DECISION DELEGATED TO DEVELOPMENT MANAGER

Application No: H02-0829-20 **Applicant:** Mr P Champion
Proposal: Rear single storey extension and garage conversion
Location: 52 Beccelm Drive Crowland Peterborough
Terminal Date: 26th November 2020

SITE BLOCK PLAN

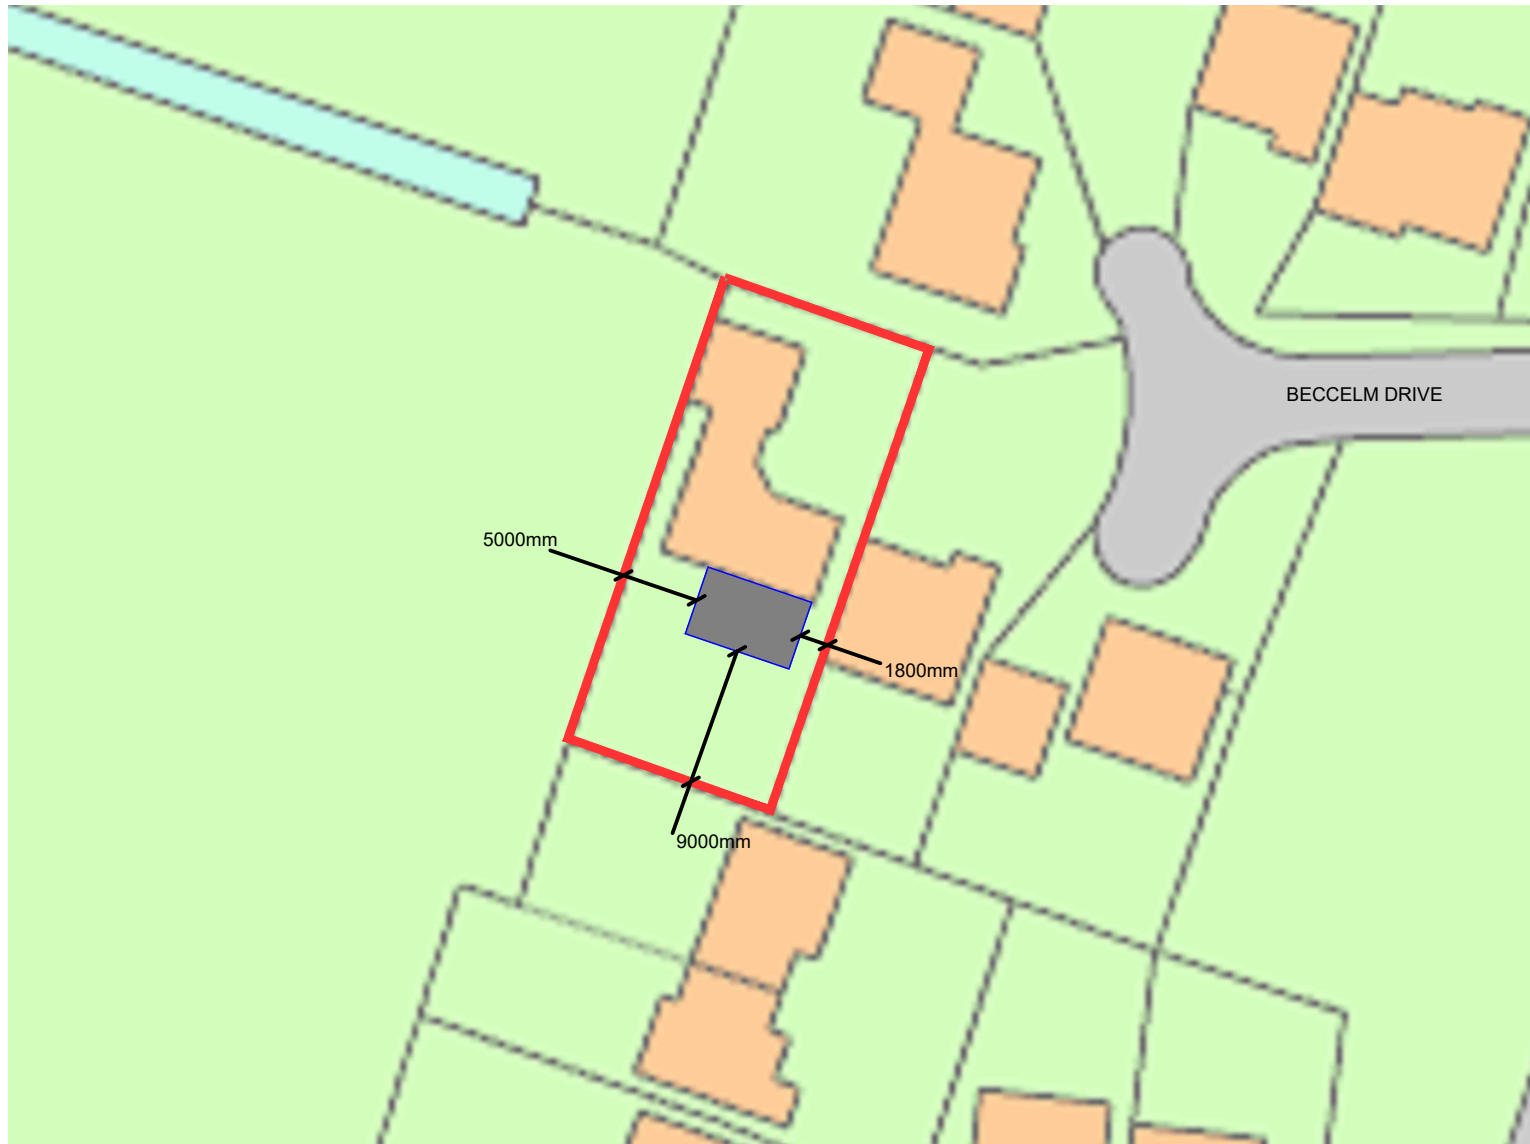
In connection with Policy 36 of the SELLP 2019, Appendix 6 sets out the minimum requirements for car parking. With the removal of one garage, there is a potential car space being removed. However, the gravelled driveway is sufficiently large enough for at least 3 car spaces to be accommodated and for them to enter and egress in a safe and forward manner.

Drawing Title:
EXISTING FLOOR PLANS

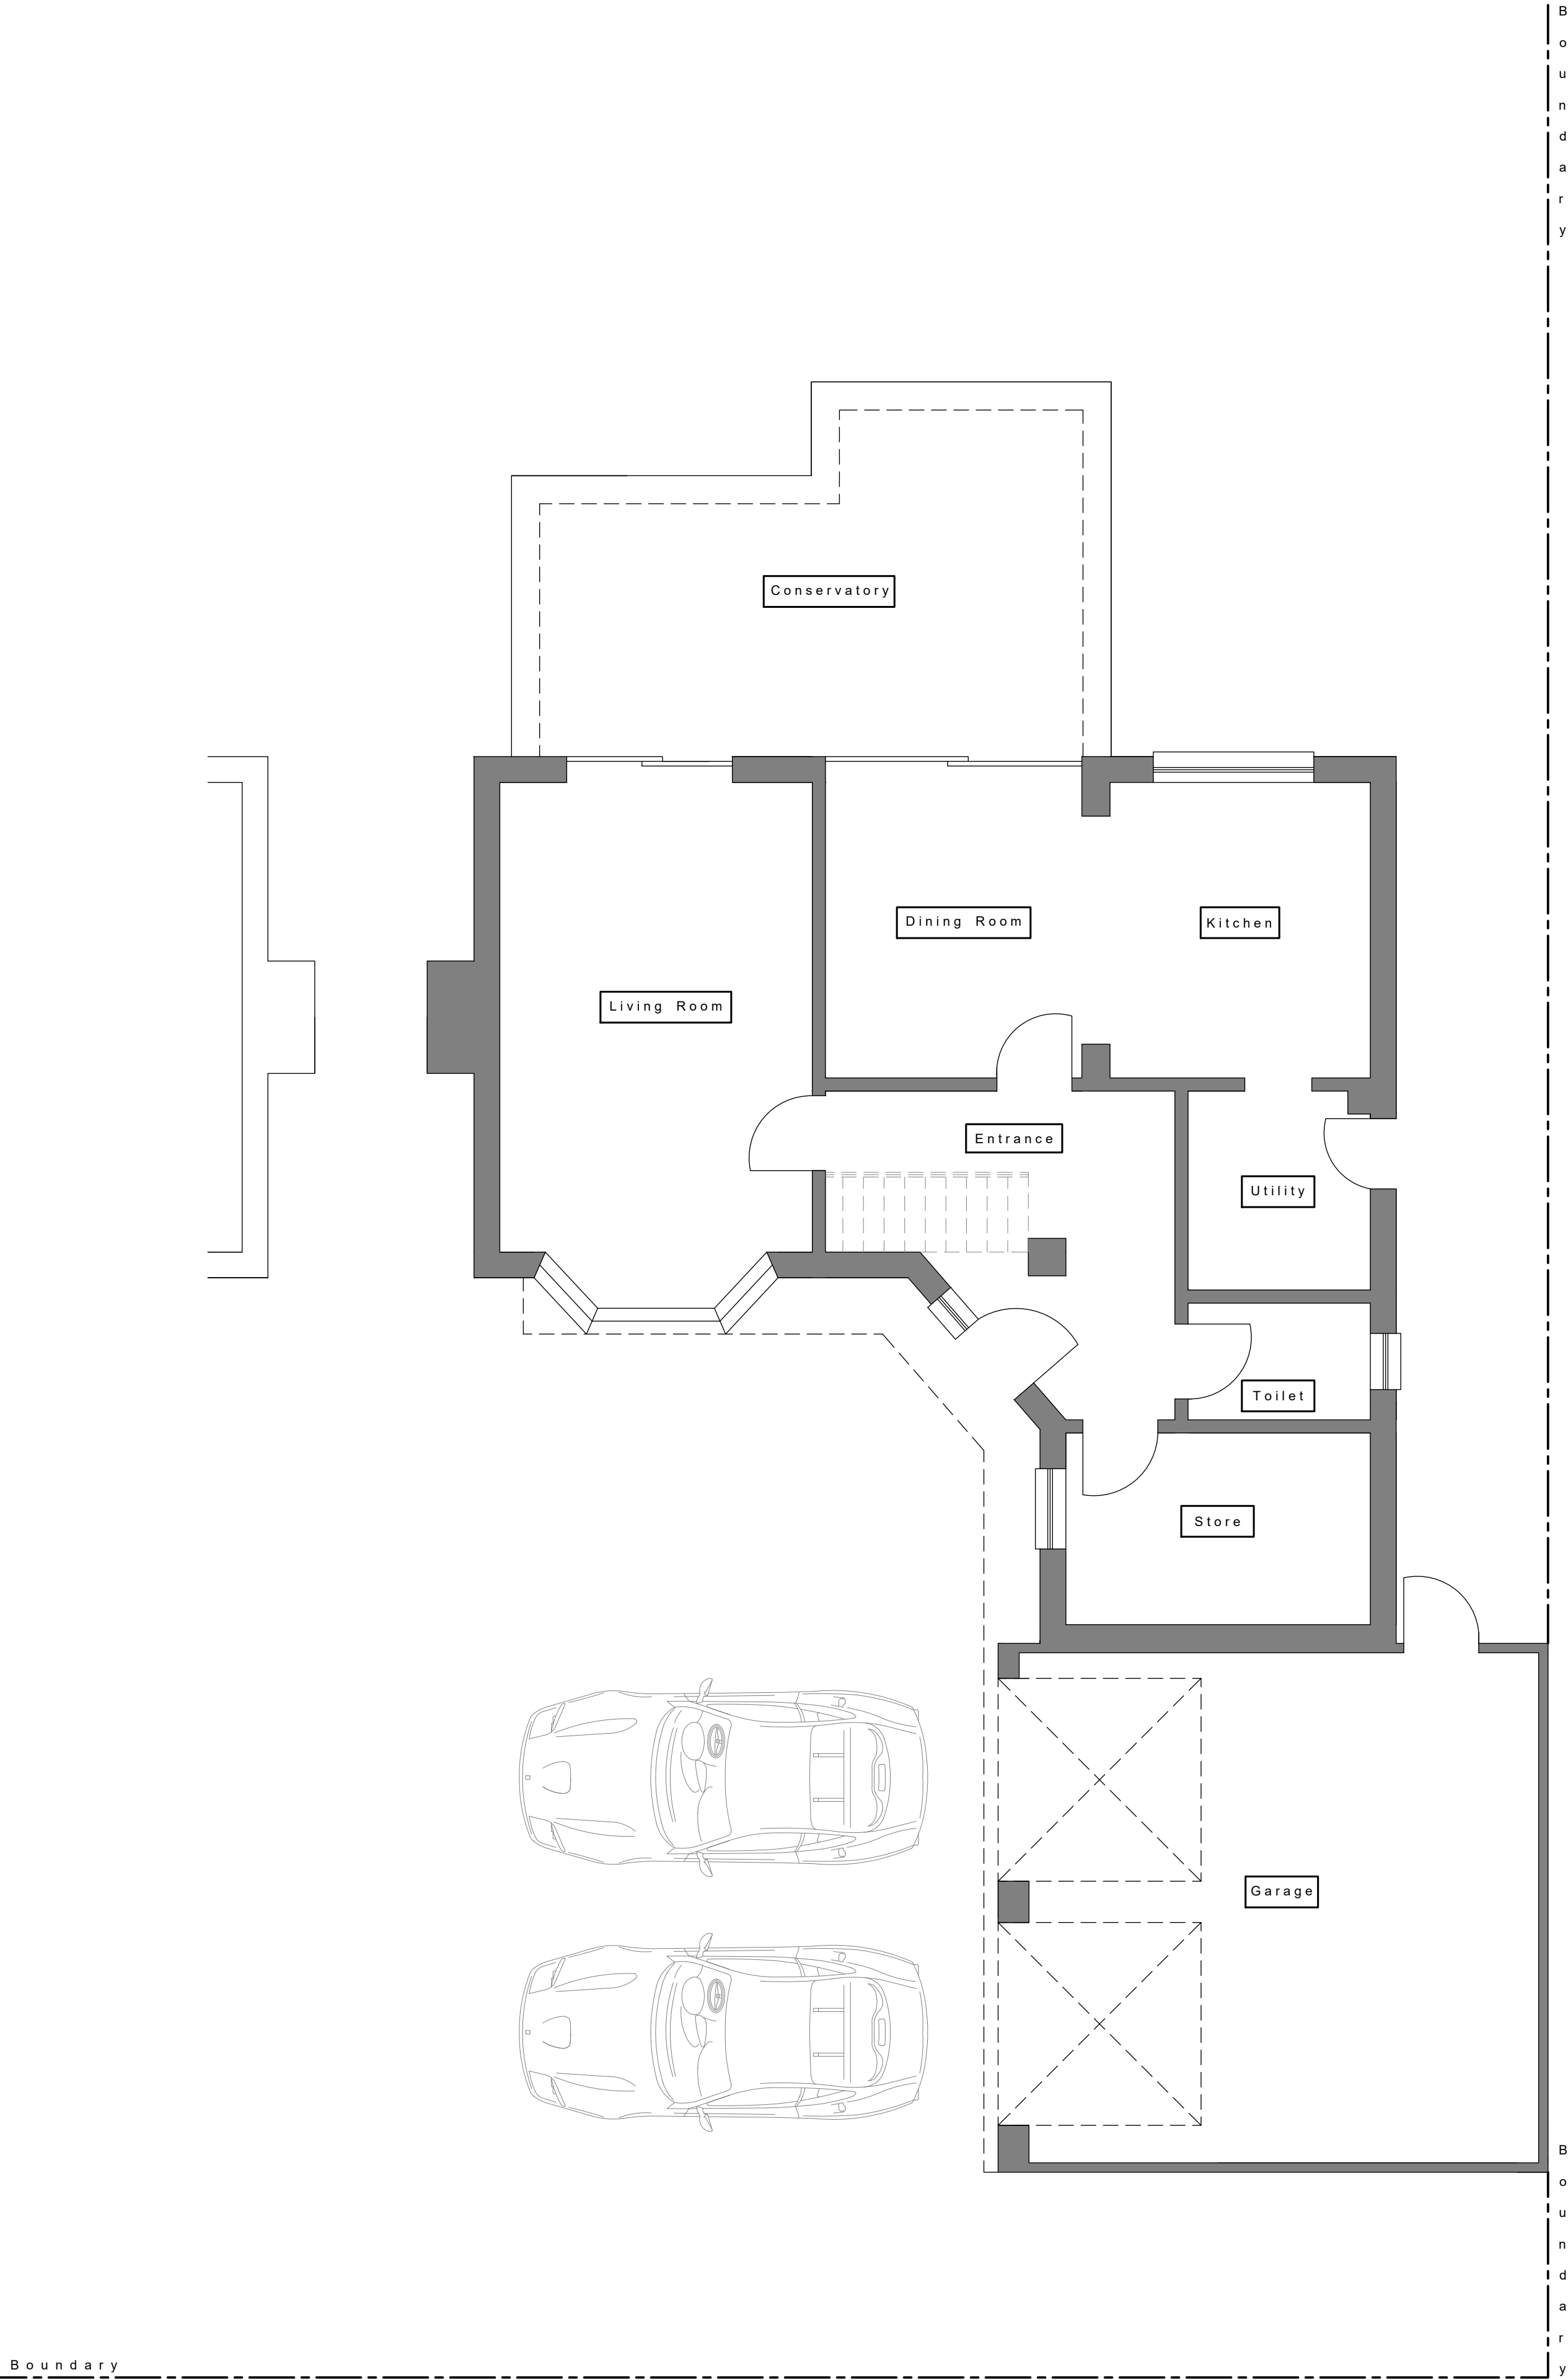
Internally, the purpose of the development is to gain further internal floor space for enlarging and creating new rooms inside the house. The extension will be slightly larger than the existing conservatory. Existing doors off the kitchen/diner will be removed to form a new opening into the extension. A single door will replace the existing doors from the living room opening into the rear extension.

Drawing Title:
PROPOSED FLOOR PLANS

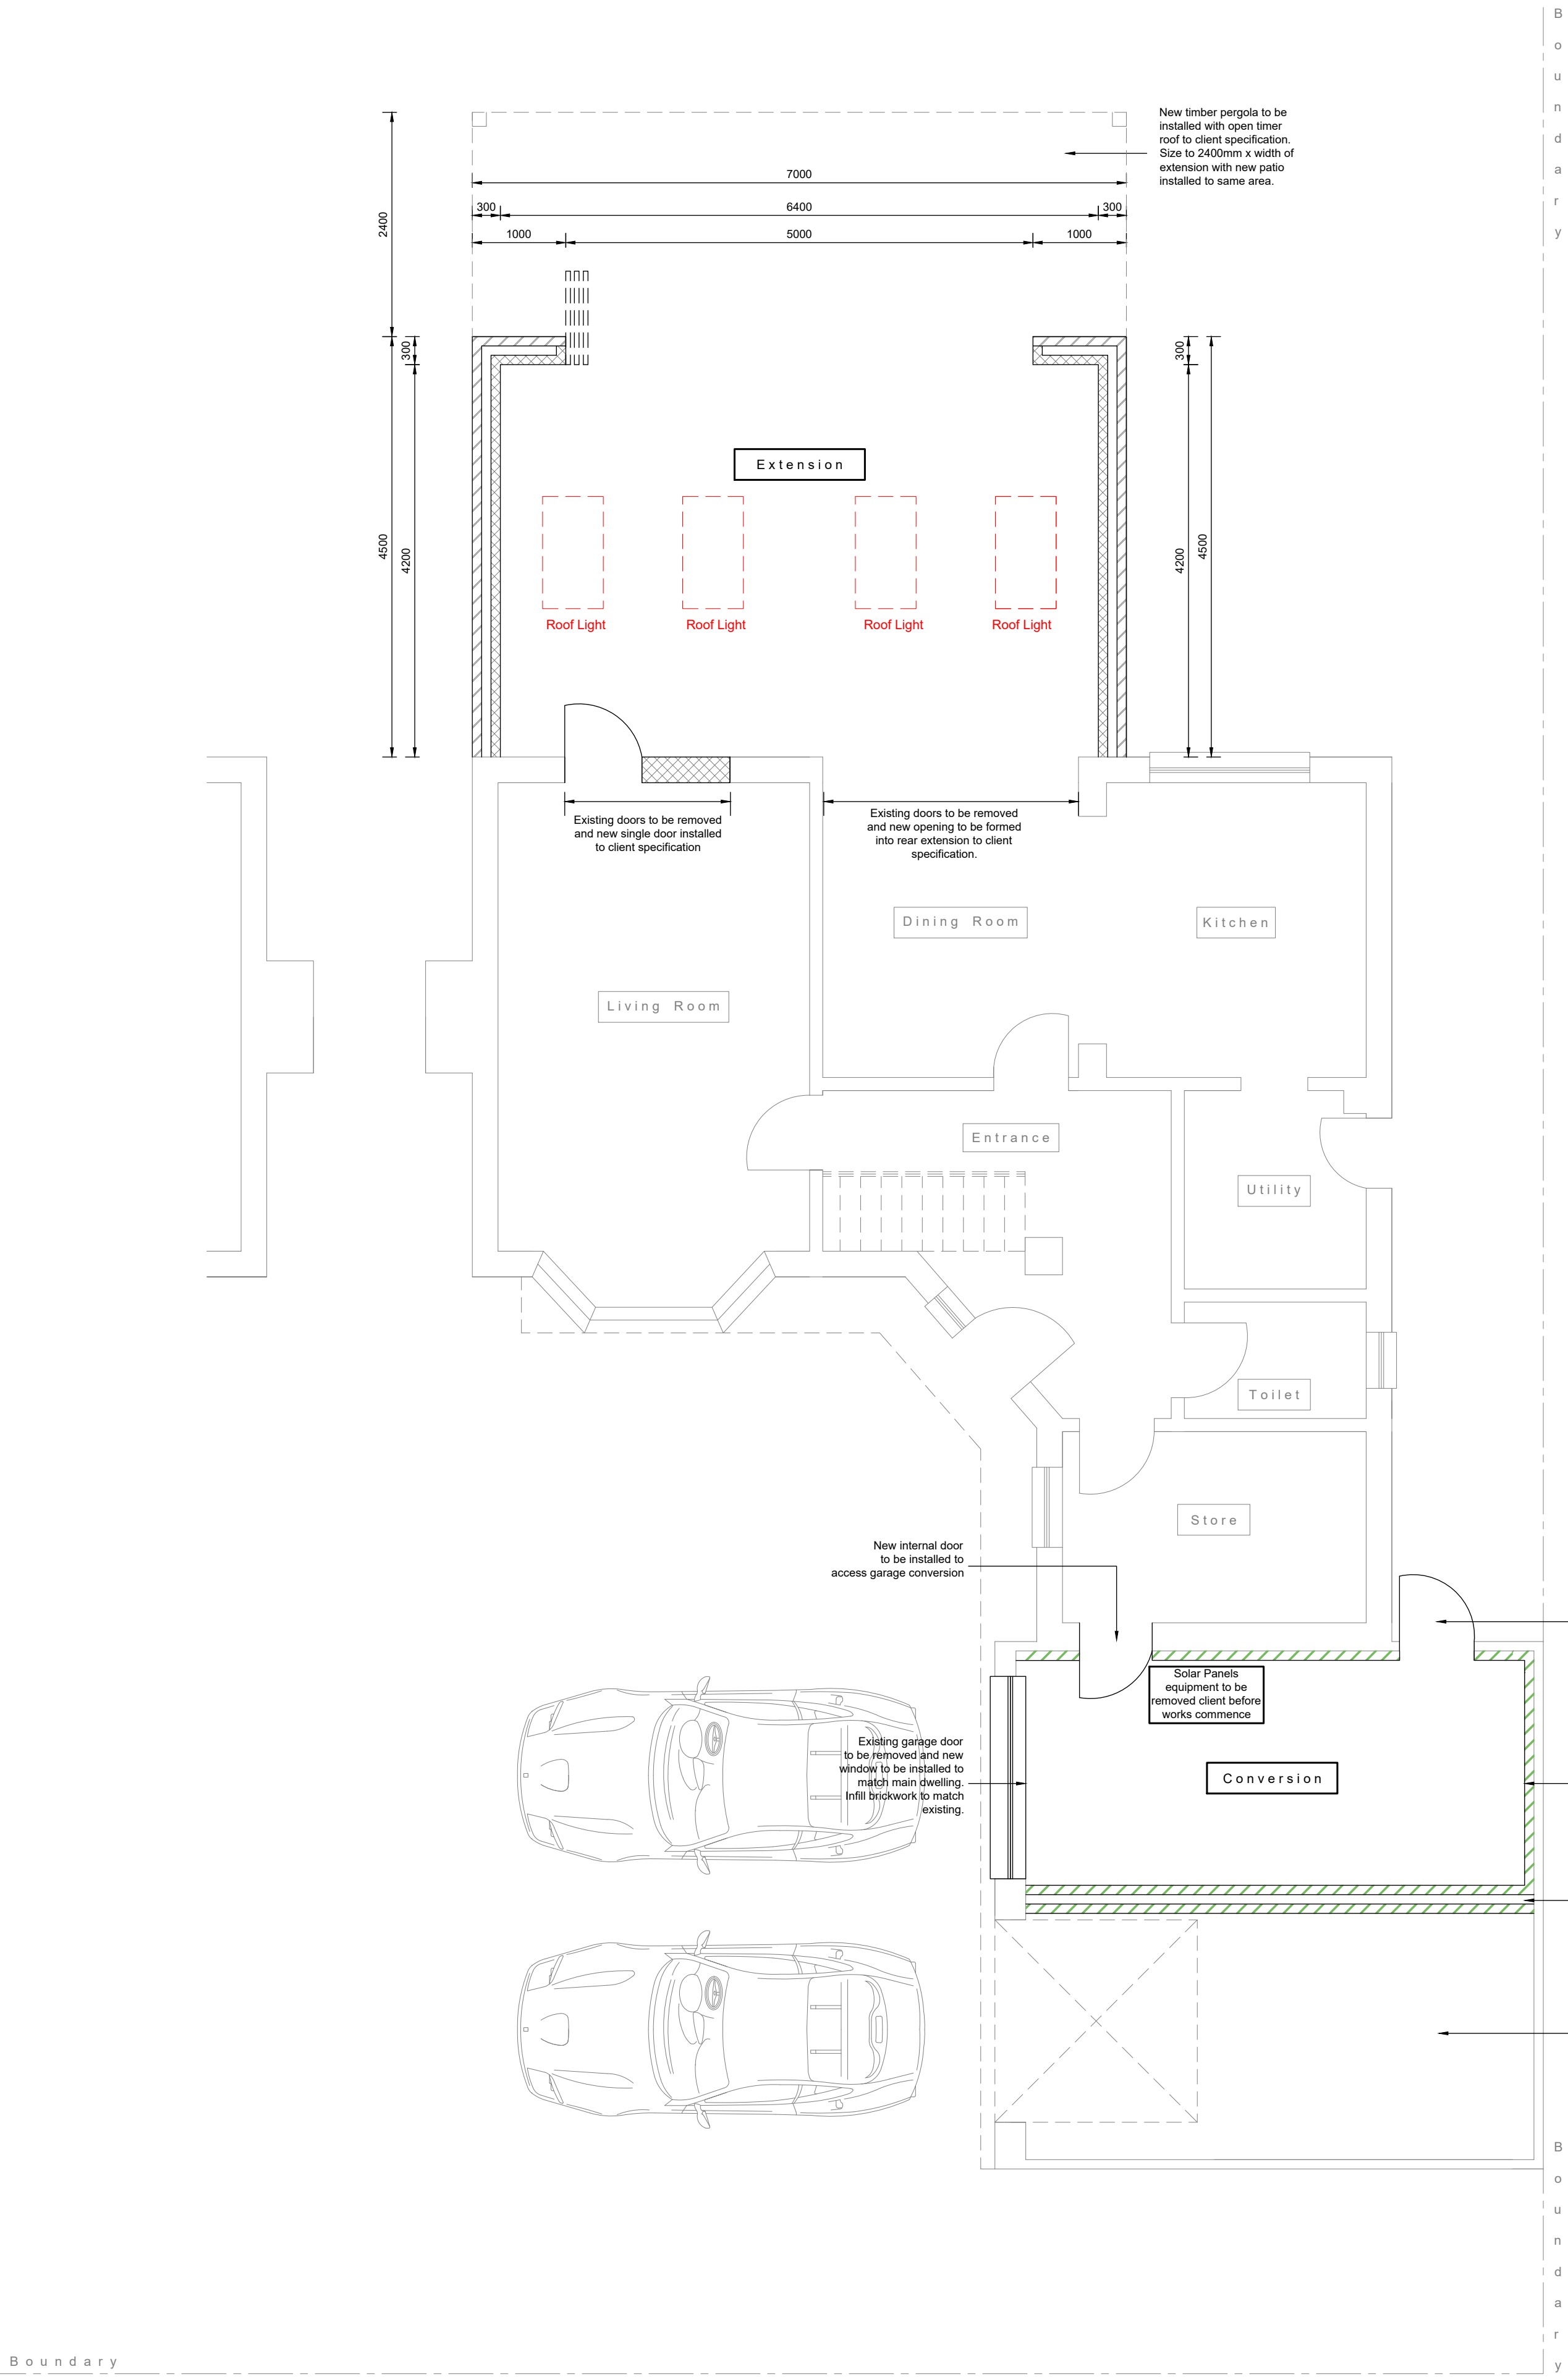
The proposed single storey rear extension will protrude approx. 4.5m, with a maximum width of 7m. The maximum height will be approx. 3.4m, to sit 18cm below the existing first floor rear windows. The existing conservatory to the rear elevation will all be replaced with the extension. The proposed development will also include a conversion of half the double garage to create an additional habitable room for the current residents off of the existing store room. Having regard to the existing dimensions of the house, the proposed addition is acceptable in terms of scale, mass and bulk.

A lean to style roof is proposed for the single storey extension which will flow well with the existing gable end roof structure on the property.

Rooflights are proposed to the roof of the extension, allowing natural light into the habitable space. There will also be large bi fold doors approx. 5m wide on the rear elevation of the extension, which will open up to a proposed timber pergola with an open roof and a new patio area. The footprint of the development will sit well within the site as proposed.

The garage conversion consists of a new fire wall to be installed, between the two garage doors. A new window will replace the garage door, which will match the existing white UPVC windows. A new internal door will be installed to gain access to the new habitable room. A proposed new glazed door will replace the existing rear garage door, providing suitable insulation.
